# VENTURE ON VENETUCCI

### FINAL LANDSCAPE PLAN

#### LANDSCAPE NOTES & SCHEDULES

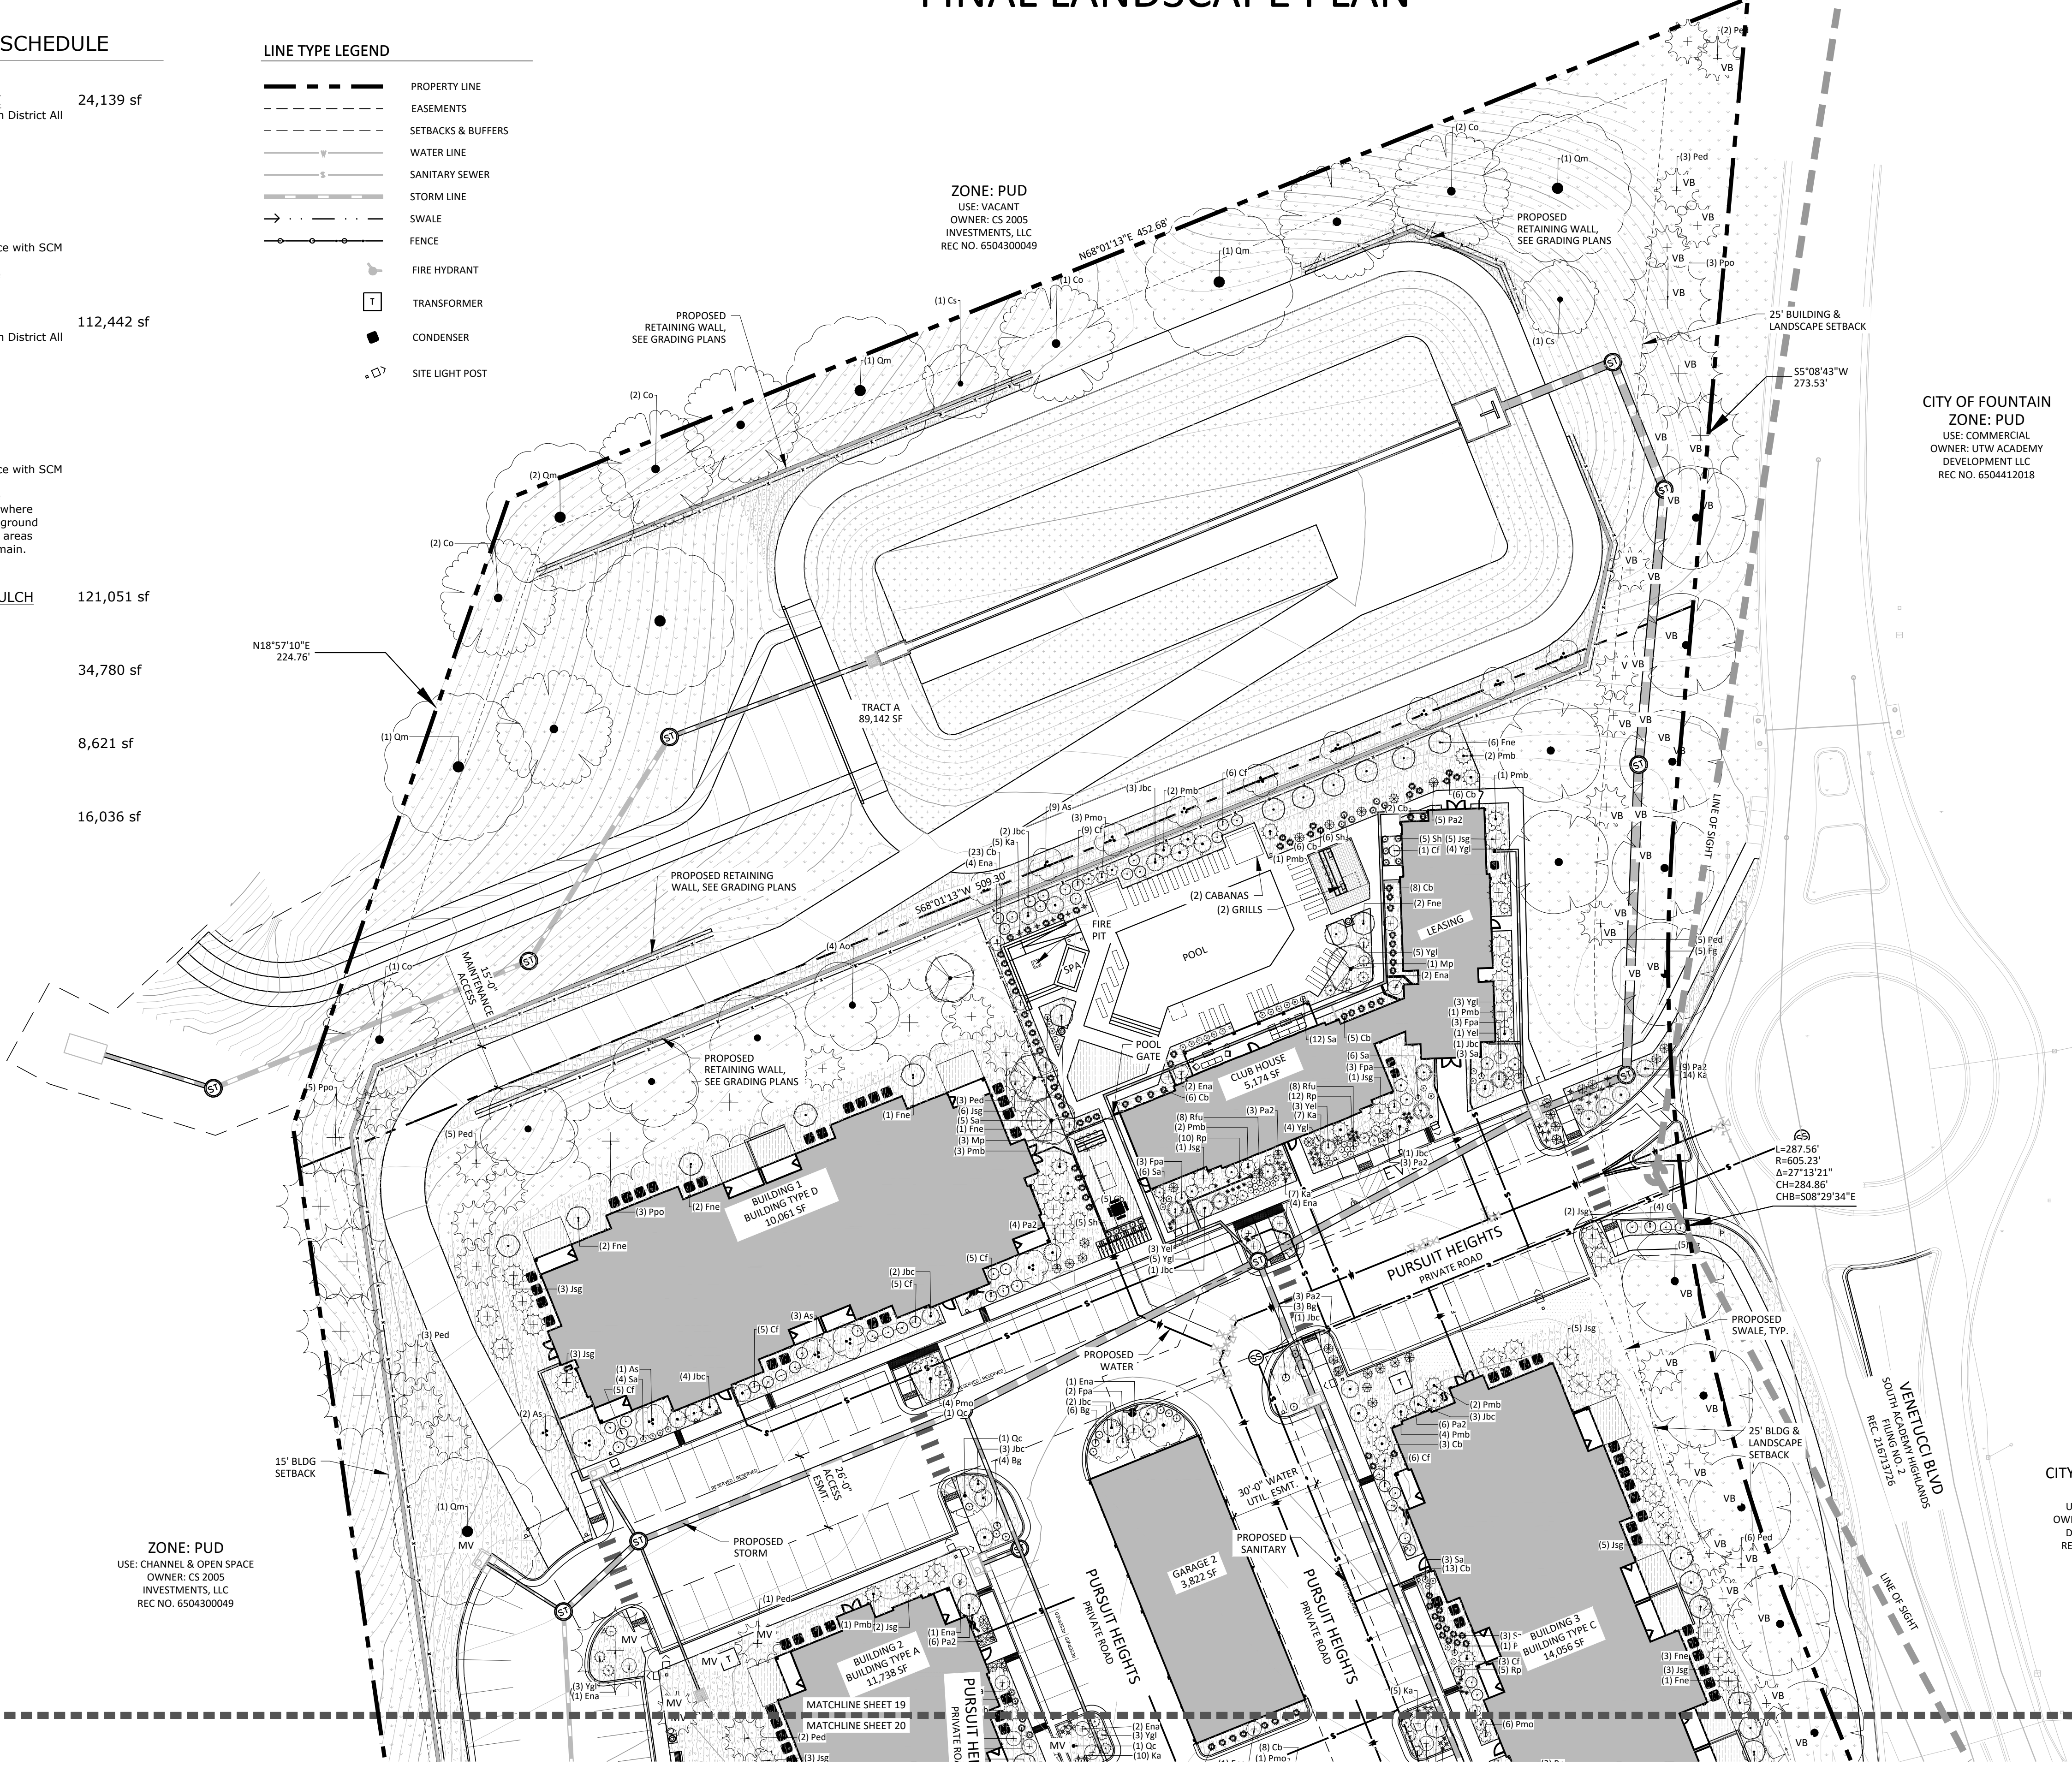
← add adj street to south

← update please

← address alternative why this is not needed...use the wide open pace channels near by perhaps or fencing to be the alternative

← buffer from commercial?

← complete this table

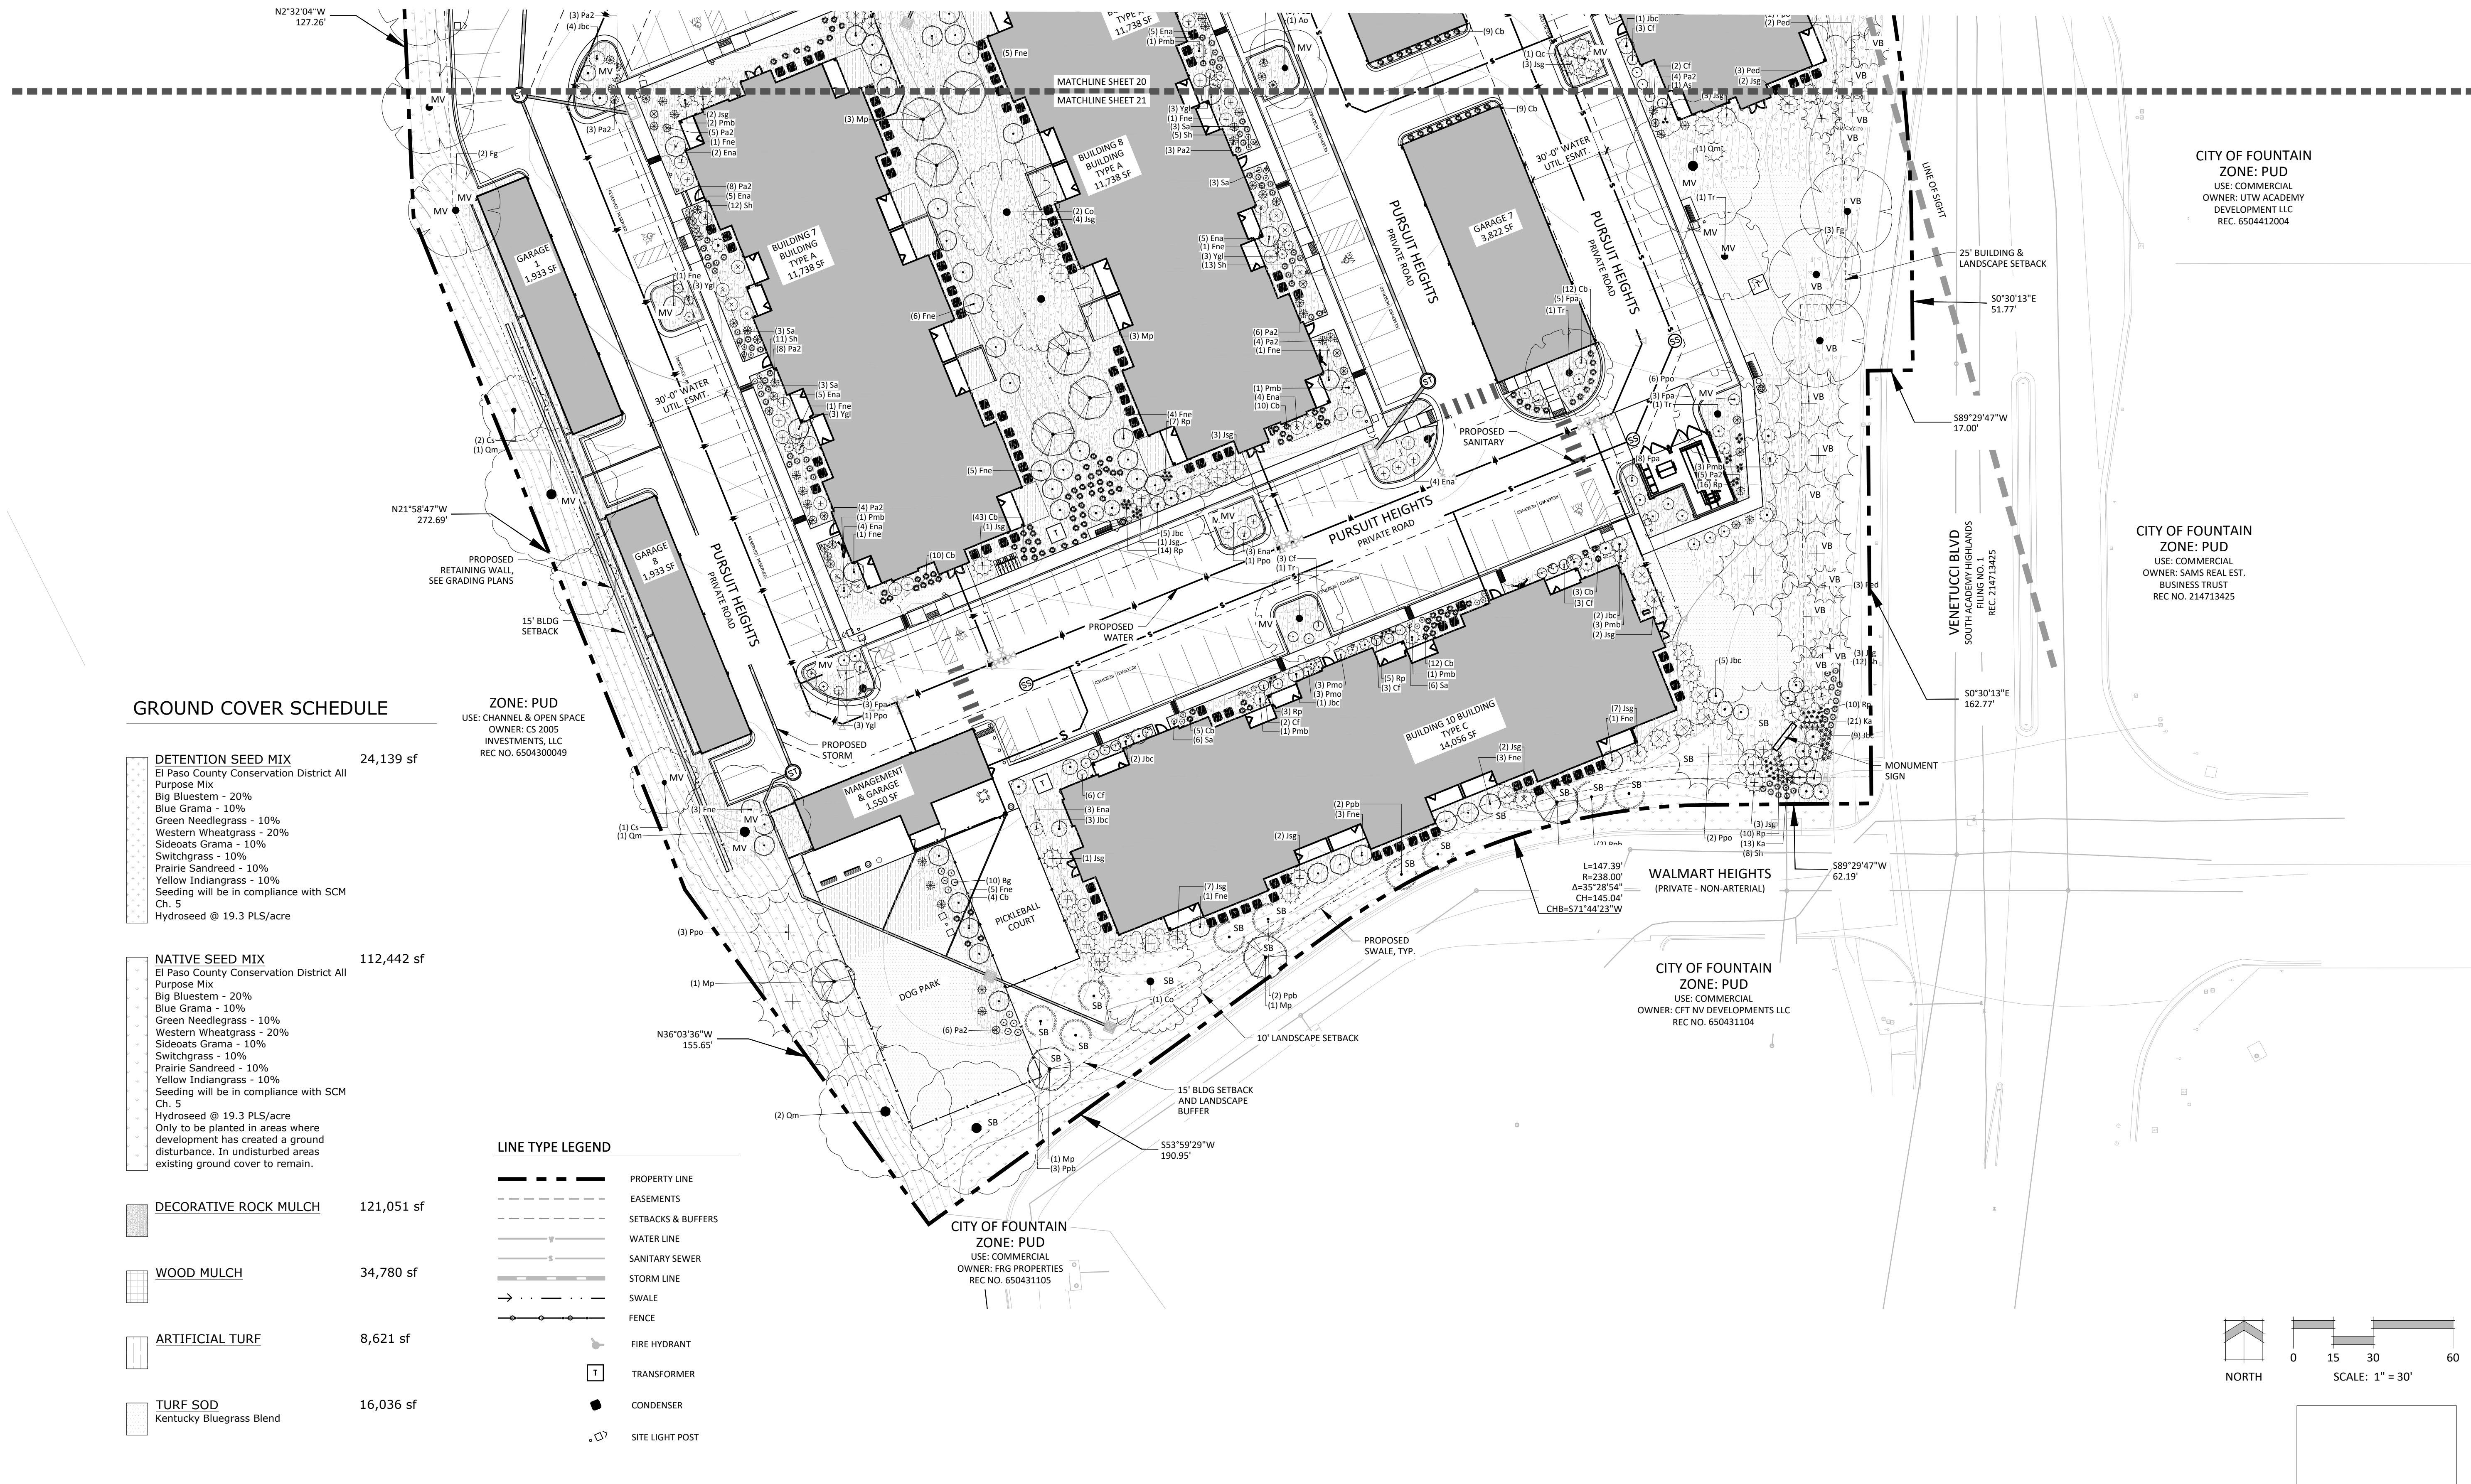
review landscape plan checklist and add missing items please  
<https://planningdevelopment.elpaso.co.com/planning-development-form-s/#1522879386032-8c72372e-2696>
